Application Ref:	3/2021/0367	 Ribble Valley Borough Council www.ribblevalley.gov.uk	
Date Inspected:	21/4/2021		
Officer:	BT		
DELEGATED ITEM FILE REPORT:		Decision	Approval

Development Description:	Single storey extension to side.
Site Address/Location:	9 Homeacre Avenue, Sabden. BB7 9HG

Drawing Title: Proposed Elevations
 Drawing No. :05
 Scale:1:100
 Paper Size A3

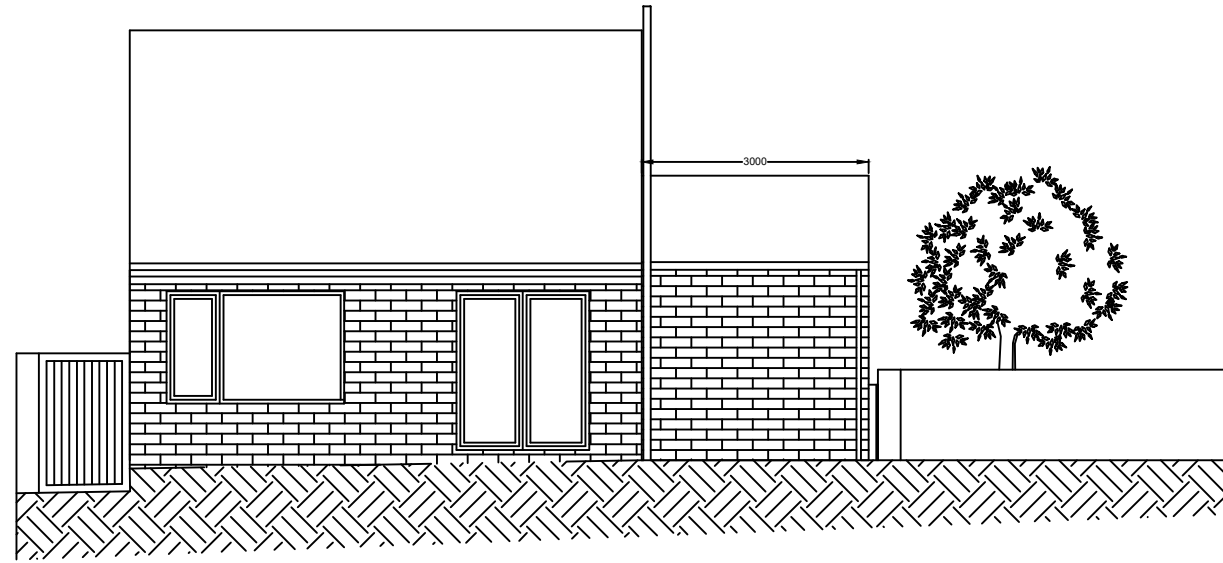
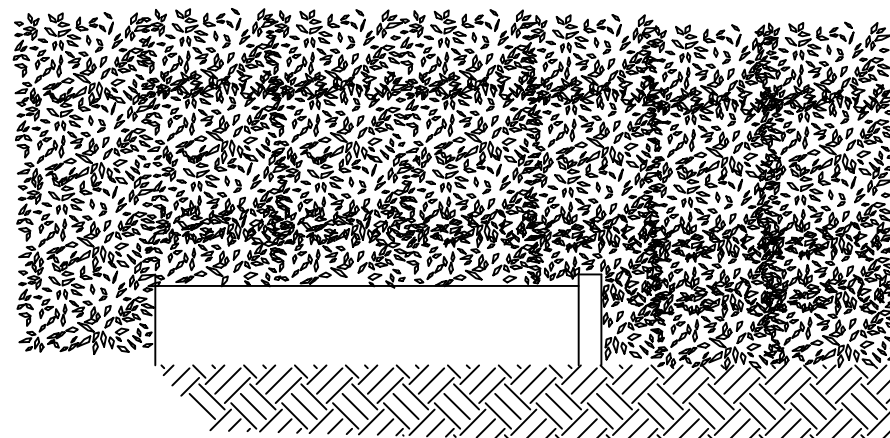
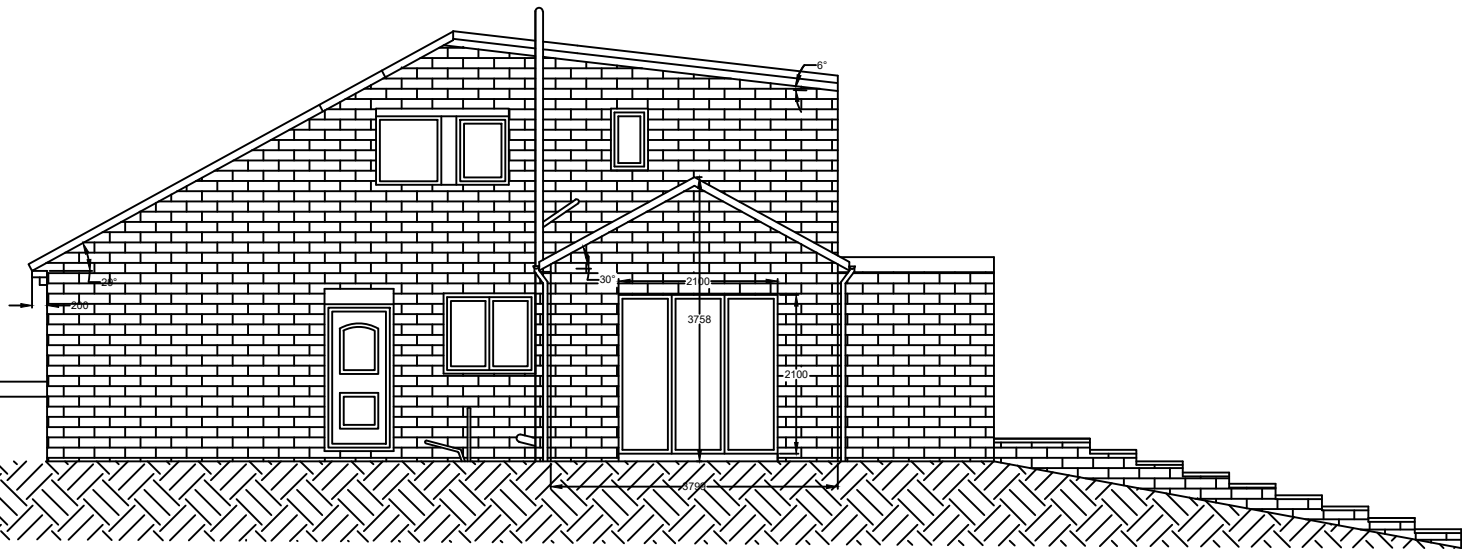
The proposed extension will incorporate a window on its front South-western elevation and a set of bi-folding doors on its North-western side elevation. The front window will allow similar views to the property's existing front ground floor windows while the extension's bi-folding doors will face towards the property's side garden and open fields. As such, it is not considered that the proposal will have any undue impact upon existing privacy levels.

The front extension will have an eaves and roof height of 2.5 and 3.7 metres respectively making it wholly subservient to the primary dwelling. The extension will measure 3.0 x 3.7 metres and as such will comprise a relatively small footprint.

The extension will be constructed from red brickwork, concrete tiles and white UPVC doors and windows all of which will match the external materials of the main property and other dwellings in the surrounding area. As such, the proposal would largely be in keeping with the character of the local area and in accordance with the above statement.

Plans from the proposal indicate that all new materials will match the materials of the existing primary dwelling and surrounding properties in the area. These materials include red brickwork, concrete tiles and white UPVC doors and windows.

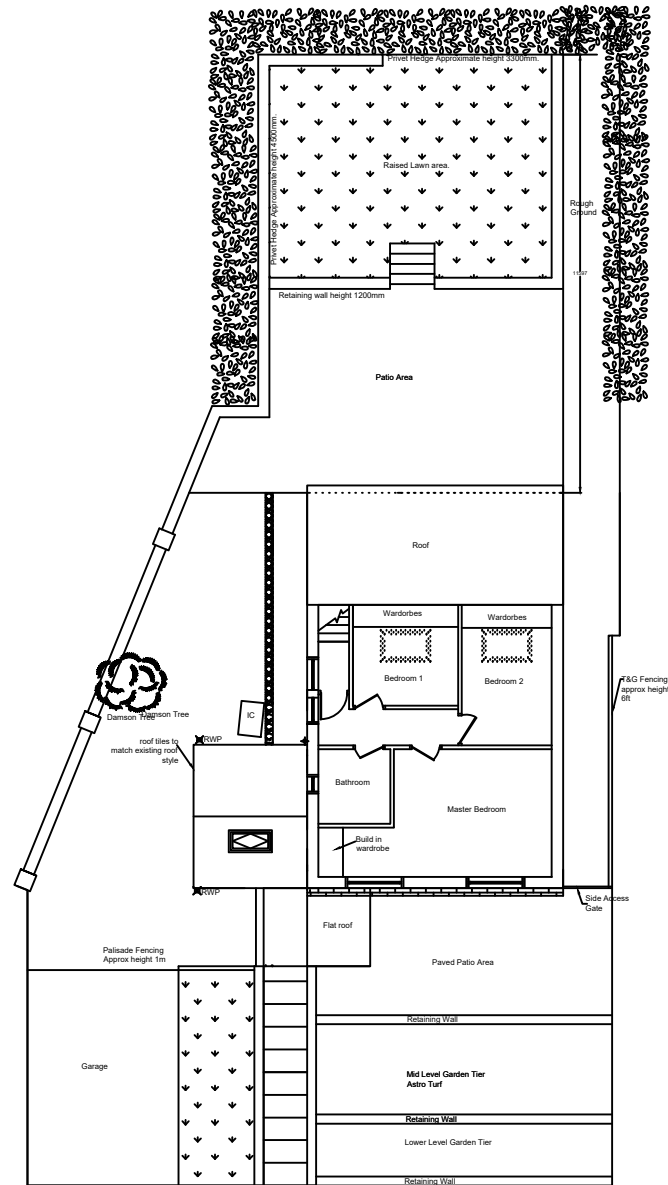
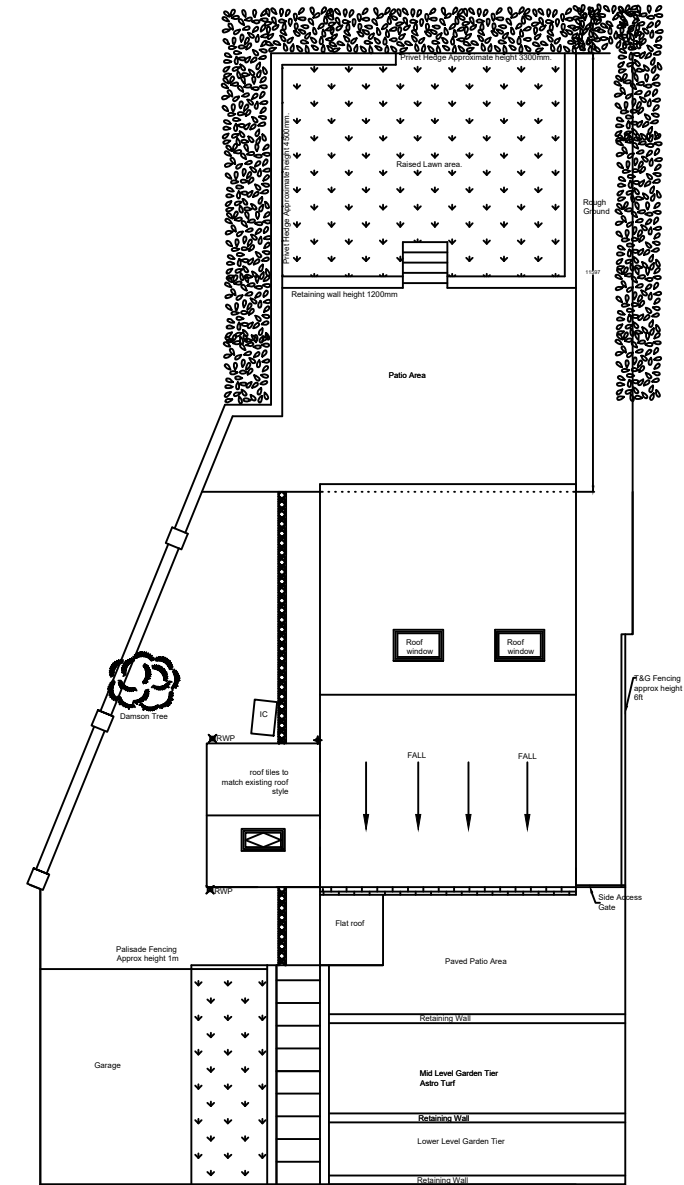
The extension will be adjoined to the property's North-western side elevation which is located on the opposite side to the nearest adjacent property of No. 7 Homeacre Avenue therefore it is not considered that the proposal will have any adverse impacts upon natural light or outlook for any neighbouring residents.
